## Lake House – Corrections Response Letter

Response to: 2012-200 Lorenzini Remodel 3R  
Dated: July 19, 2021  
Permit #: 2012-200  
Project address: 3310 97th Ave SE  
Mercer Island, WA 98040

**Re:** *Lorenzini Remodel (Lake House) at 3310 97th Ave SE Permit No. 2012-200*

SHEET NO.
S4.2

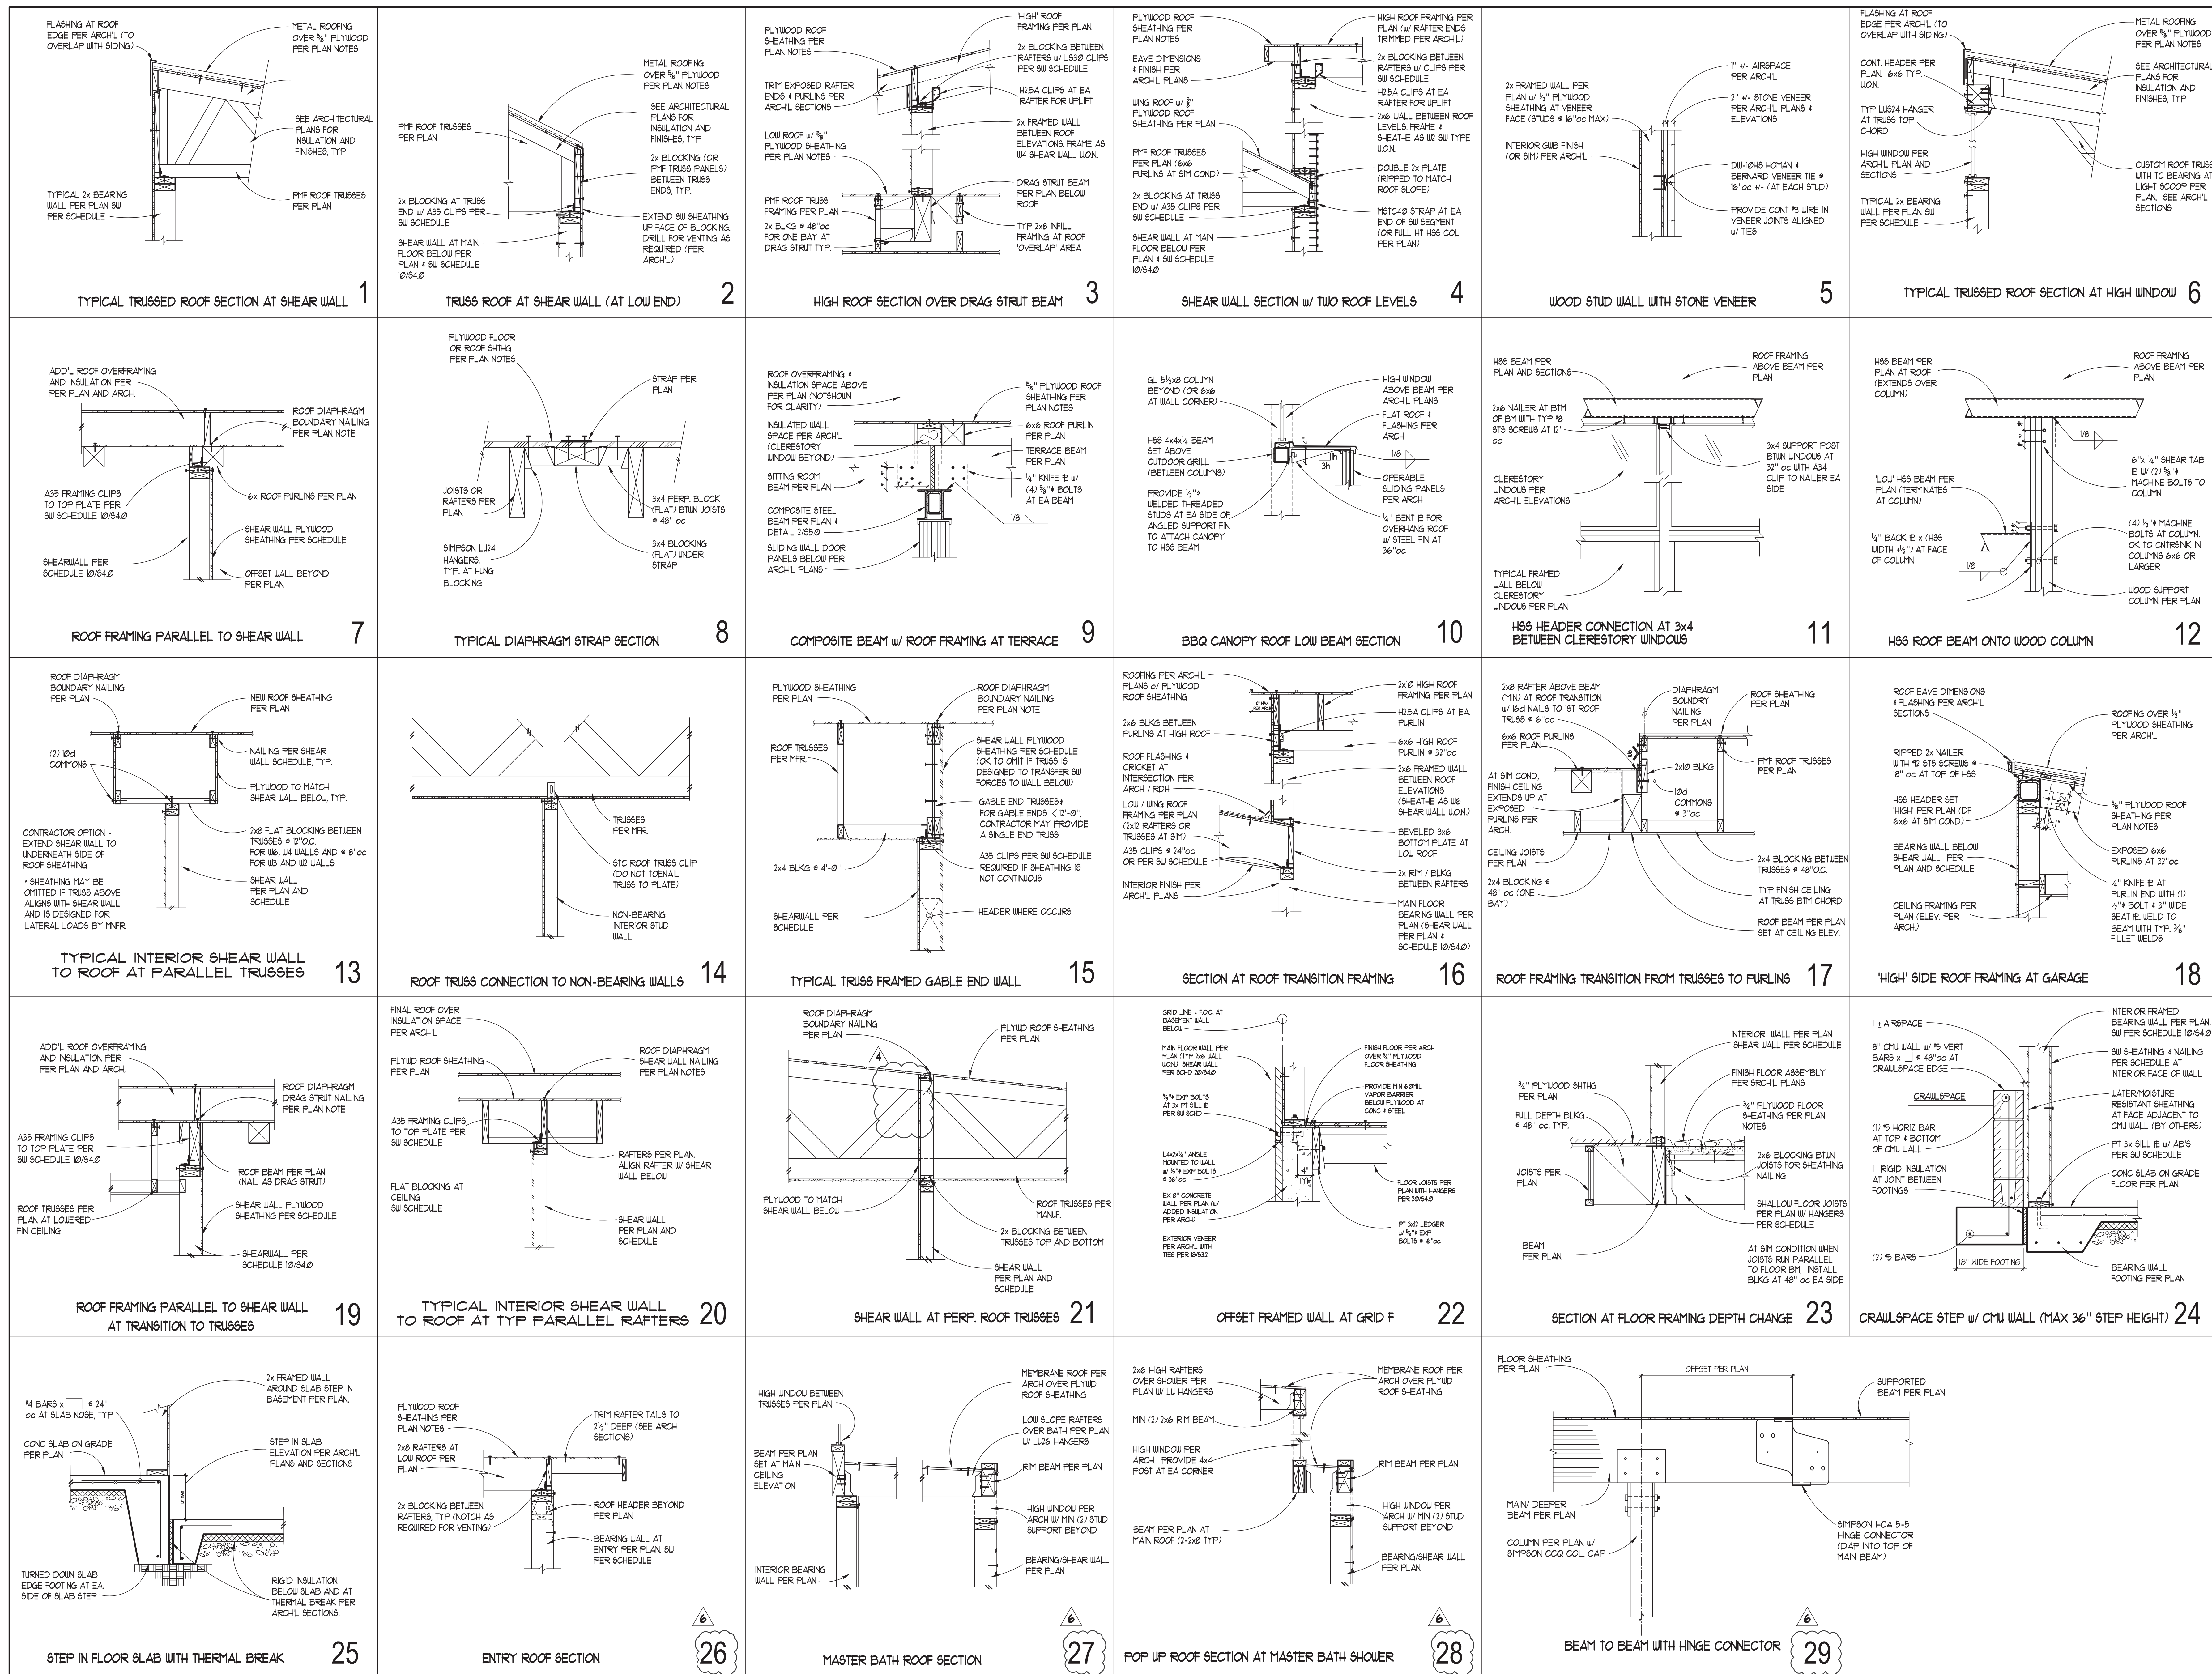
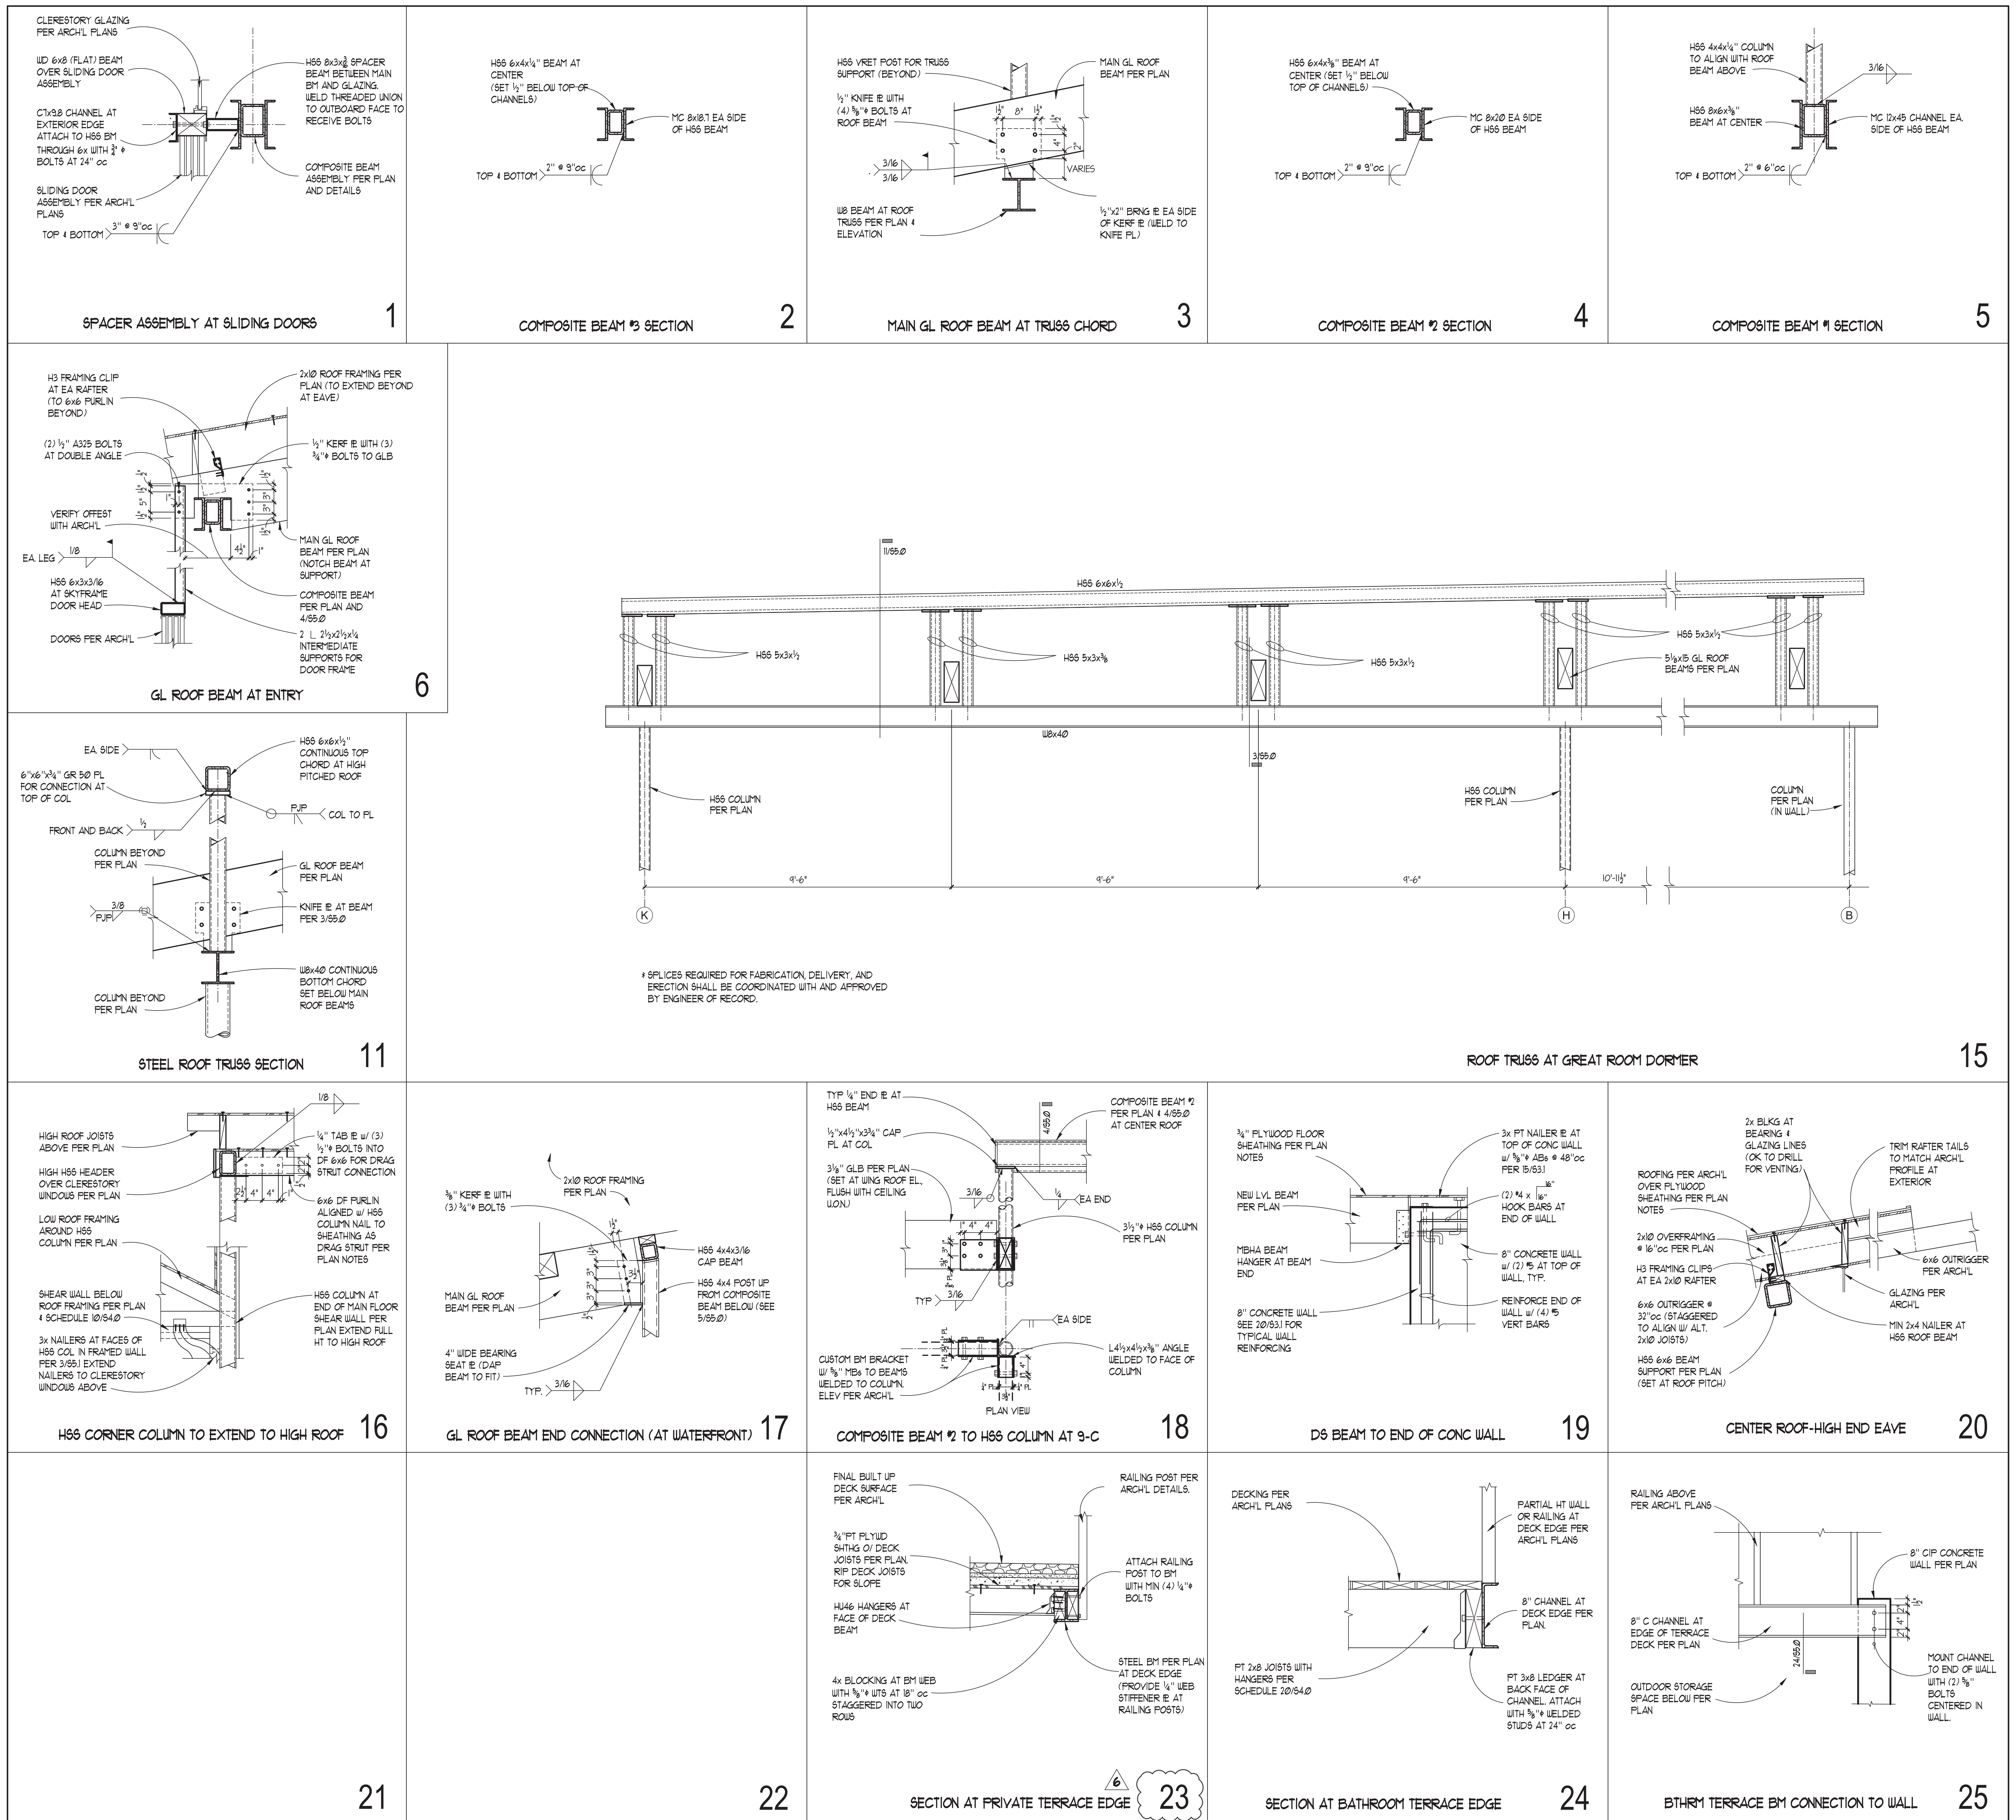
3. Detail 16/S4.2 is cut on the Roof Framing Plan at the east end of the central high roof. This detail does not exist. Please cut a detail at the east perimeter of the central high roof to show uplift connectors.

*Detail 16/S4.2 has been corrected to print on sheet S4.2 correctly.*

OPEN FRONT DIAPHRAGM REQUIREMENTS PER 2015 NBS SPPURS 4.2.5.2

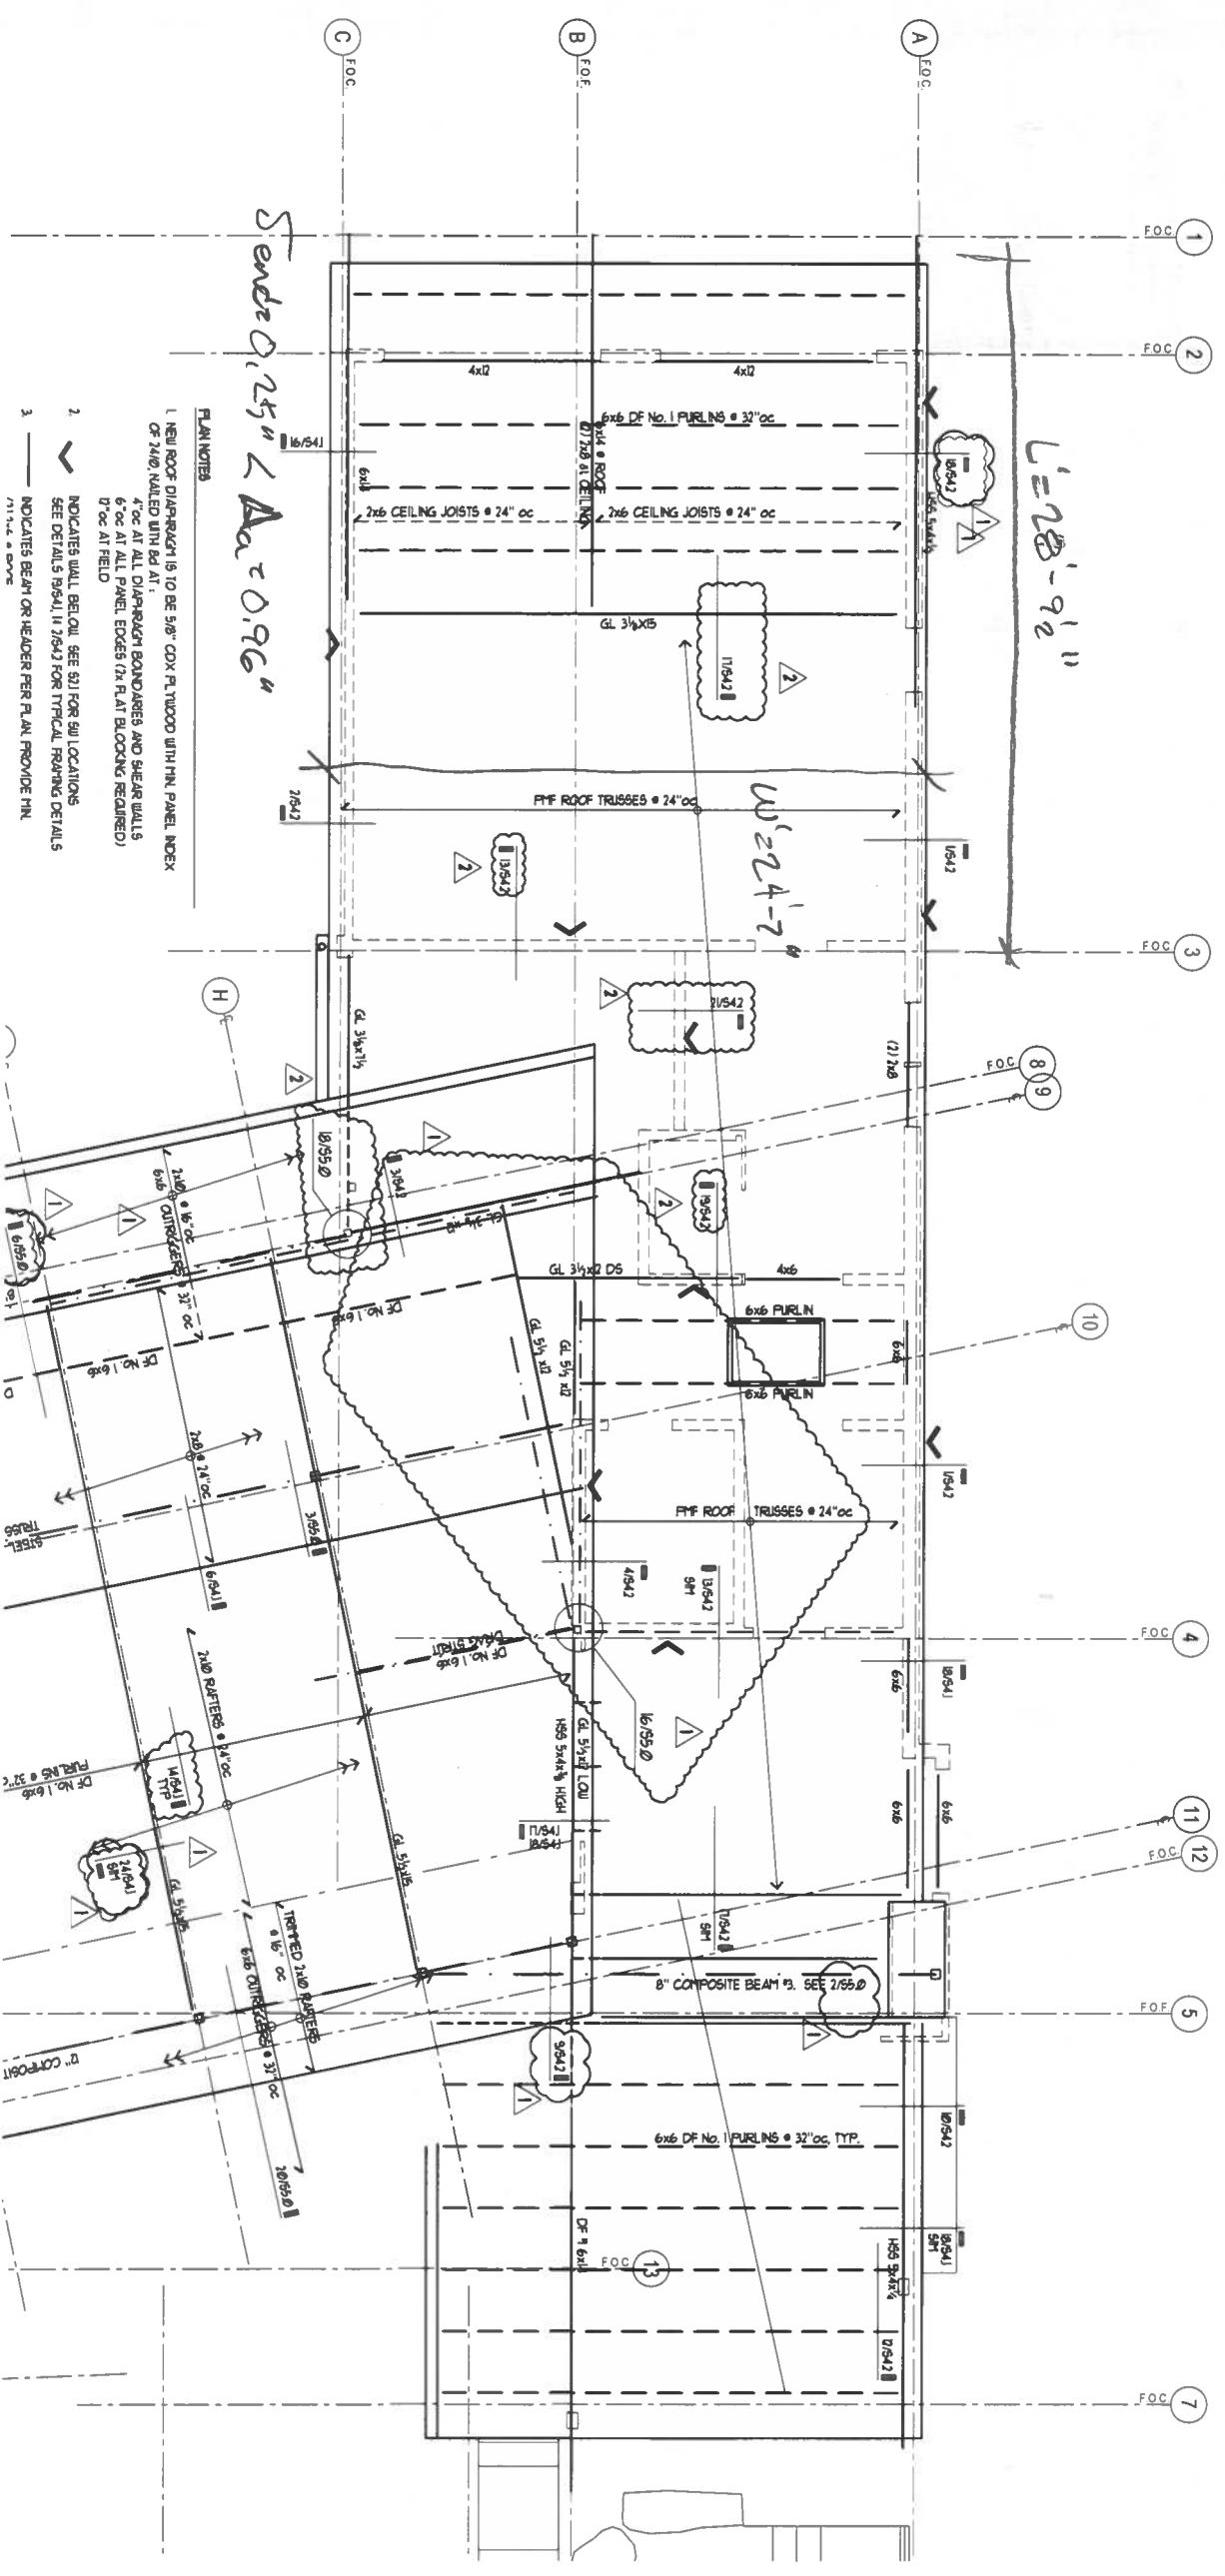
2. For resistance to seismic loads, wood-frame diaphragm in open-front structures must meet the requirement in SDPWS 4.2.5.2. Please refer us to specific pages in the calculations that evaluates this condition as we are unable to locate them.

*The open front end of the west wing has been evaluated to meet the requirements of SDPWS 4.2.5.2. Specifically, the roof structure is designed with a blocked diaphragm at the roof which was evaluated using a rigid diaphragm analysis to accurately distribute the loads in the diaphragm including the torsional effects created by the open front at the garage doors. The main floor shear walls in this wing were designed for the resulting loads. A copy of the rotational analysis of the diaphragm and shear wall calculations are attached to this letter.*
